Application for a non-material amendment following a grant of planning permission.
Town and Country Planning Act 1990

Sutton St James

Proposed telecommunication equipment

H20-0763-16

Drawing Title:	LEASE DRAWING
Purpose of issue:	PLANNING
Drawing Number:	101
Surveyed By:	SH
Drawn:	SPD
Original Sheet Size:	A3
Checked:	DS
Date:	17.06.16
Issue:	B

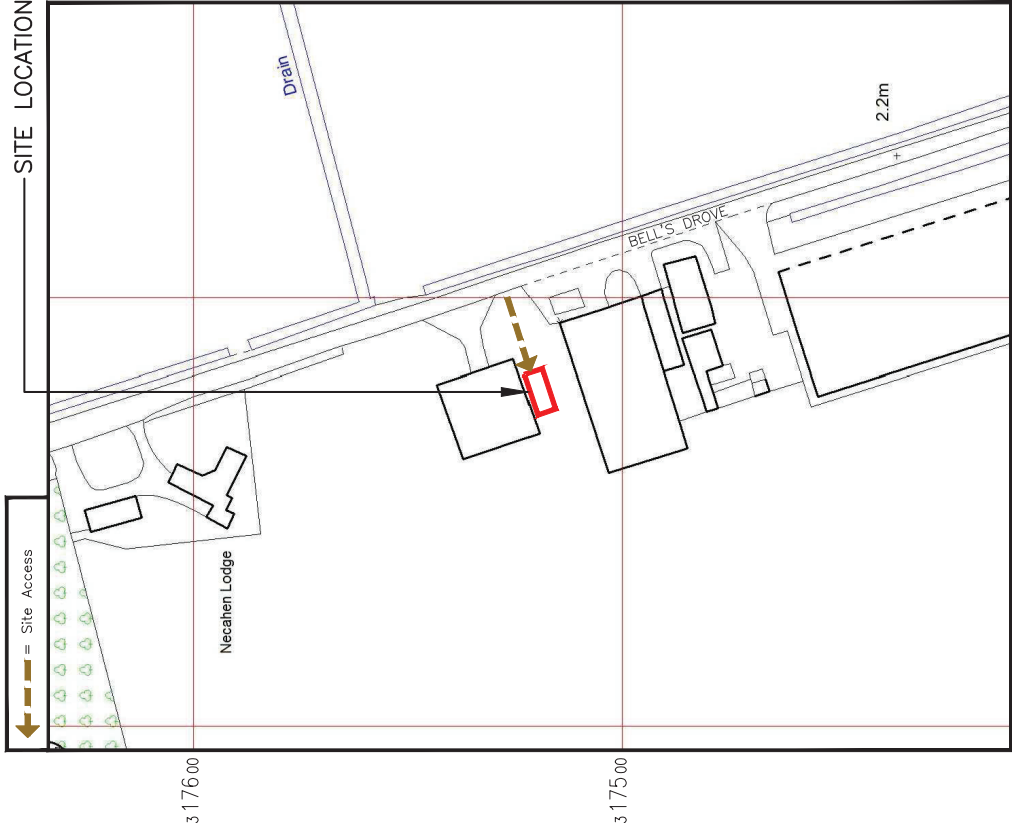
Relocation of lattice tower, cabinets and ancillary equipment to new location approximately 3.9 metres to the north of current location. Fence line surrounding tower and cabinets to move to the new position and reduce in size to 4.4m x 6m.
Within the compound, the type of, and position of the tower and cabinets will remain the same as per the original application.

Underground pipework has been found at current compound/ tower location and so site is to be moved slightly to the north to avoid damage to the pipes.
